23 February 2026

Re: SSD-86878982 - Seniors Housing at No. 132-134 Beecroft Road, Beecroft

The following comments are provided for consideration and to assist the Department in the assessment of the SSD application.

Figure 10 - Council flood hazard mapping – Council GIS Mapping

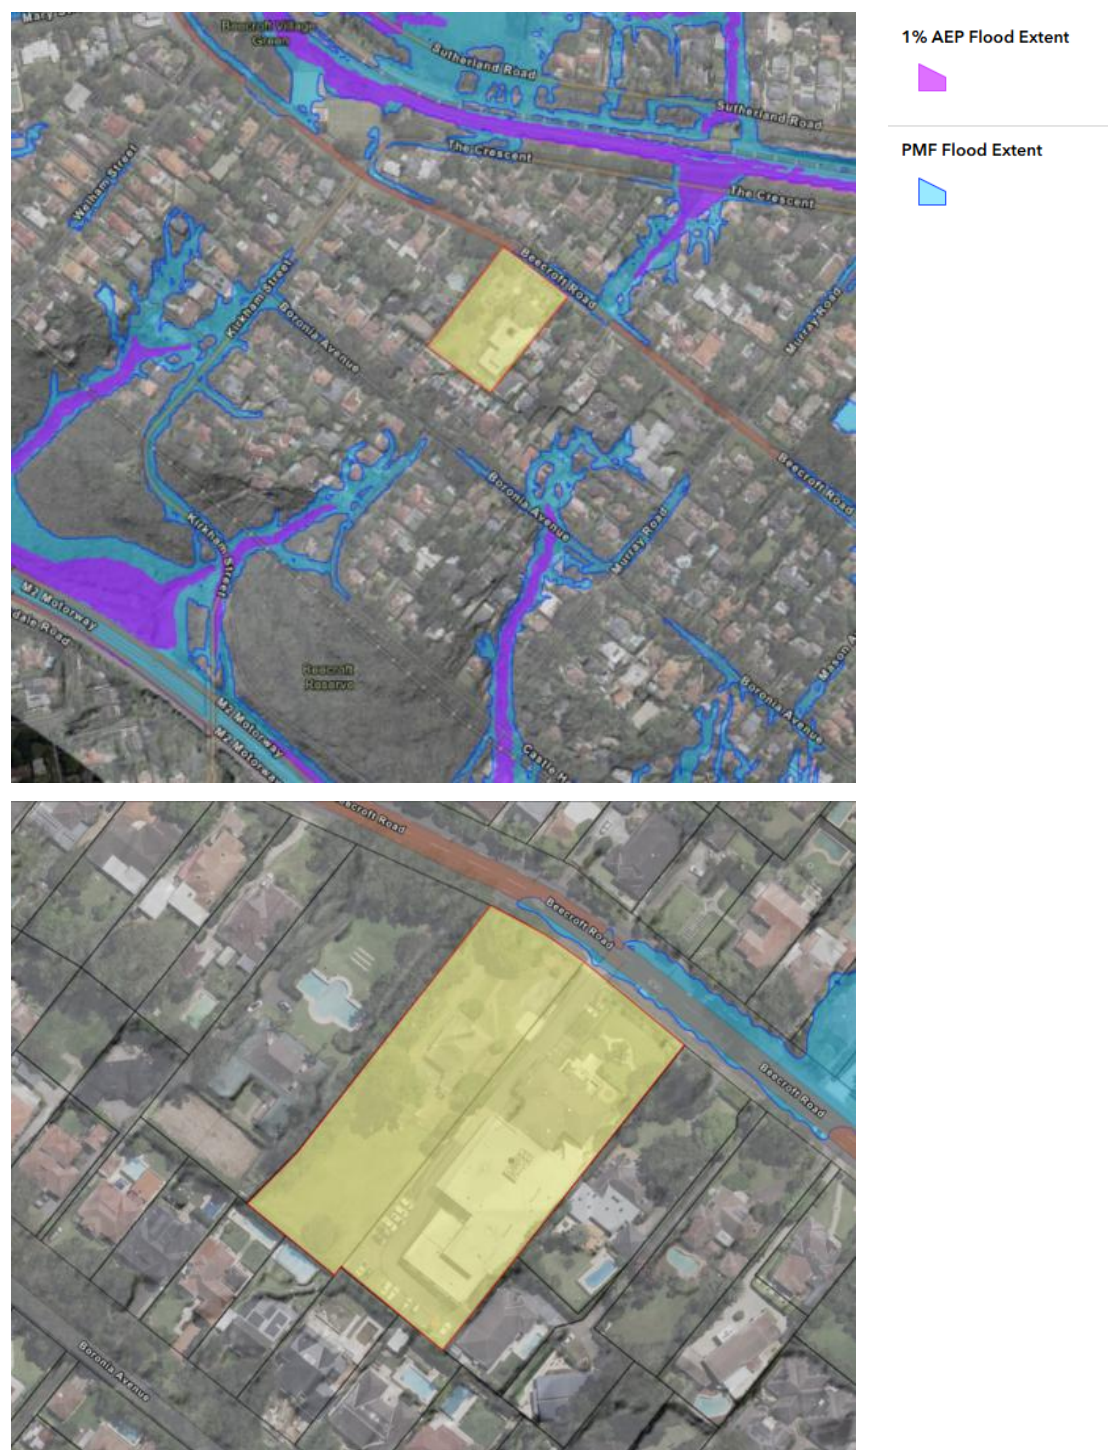
The proposed OSD system discharges directly to the public drainage system in Beecroft Road that is proposed to be extended to the street frontage of the development site. Hydraulic grade line calculations shall be provided to demonstrate that the OSD is not affected by back water affects from the public drainage system.
